PLANNING AMENDMENT

7 MARKET PLACE (INCORPORATING 18-19 BRIDGE STREET & 1 MARKET PLACE),
SPALDING

EXTENSION TO RETAIL SHOP.

Amendment: Revisions to rear, side & fire doors & escalator lighting
Dwg.Nos.1271/02C; 1271/03C & 1271/04A

DRAWING NO.
1271/02

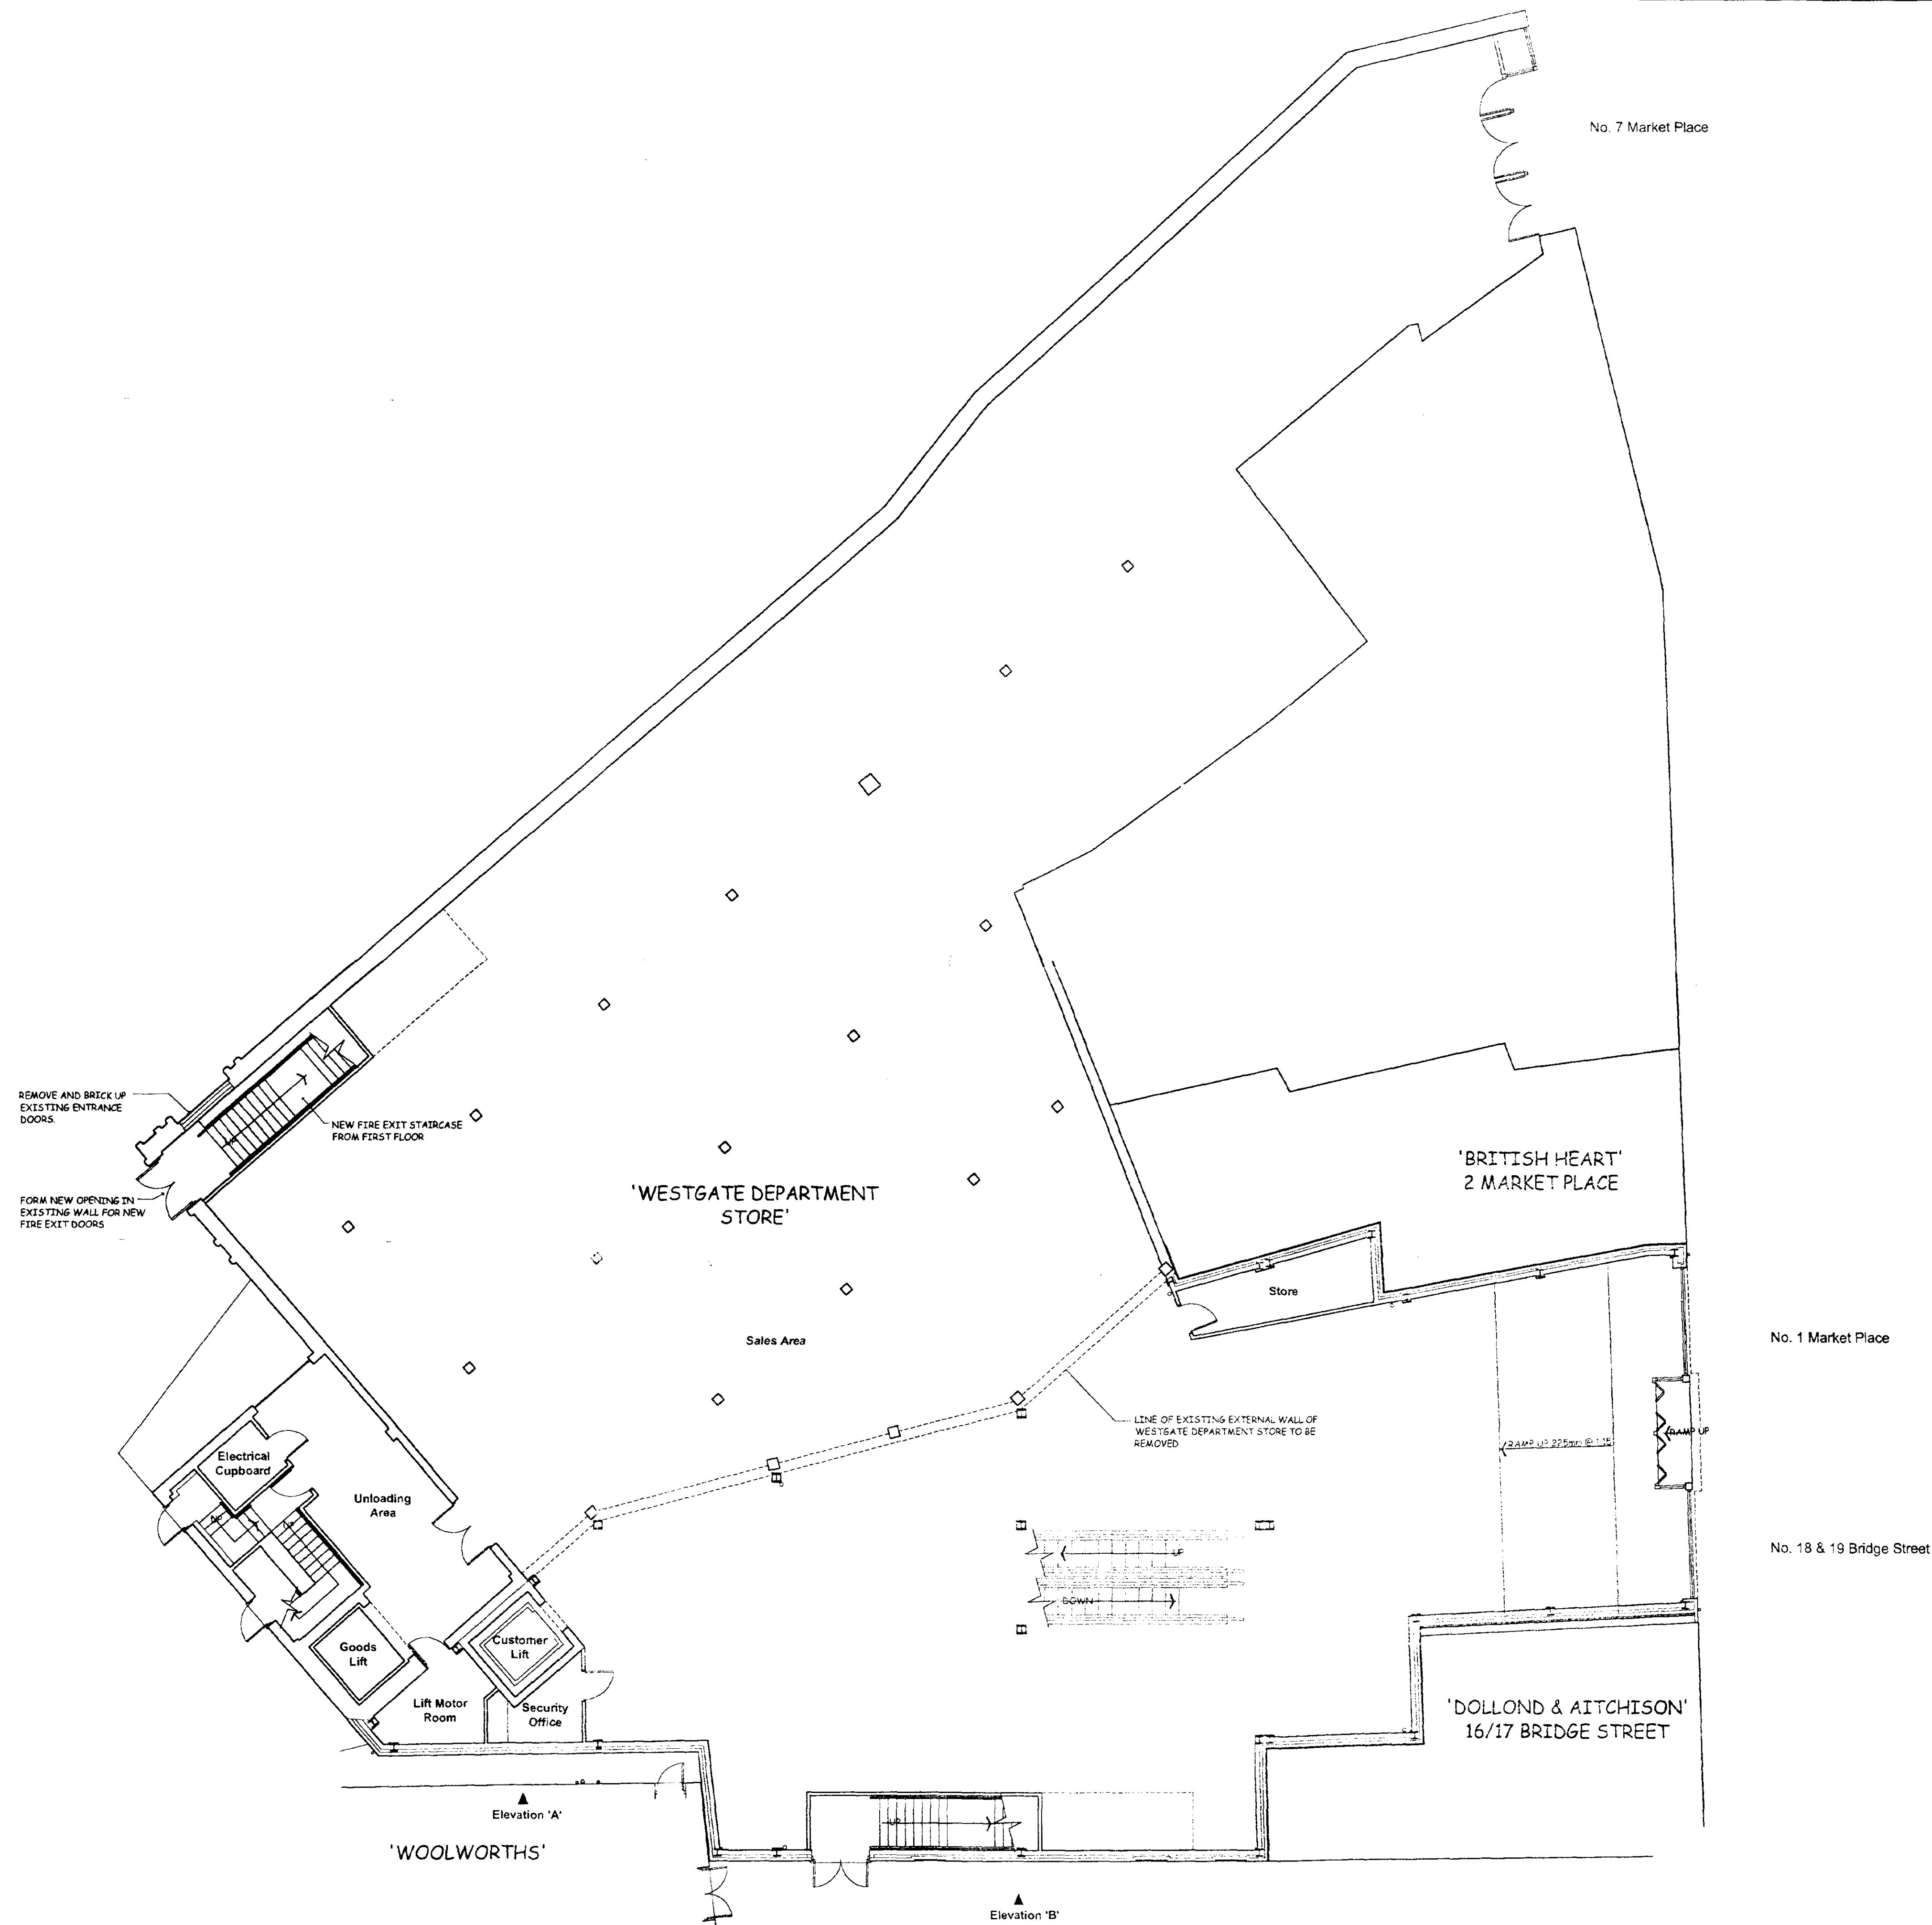
BRICKING UP EXISTING REAR ENTRANCE &
FORMING NEW FIRE EXIT TO REAR OF
EXISTING BUILDING.
THE ADDITION OF A GLAZED LANTER LIGHT
OVER THE ESCALATORS.
DOOR POSITION ON PROPOSED SIDE
ELEVATION REVISED.
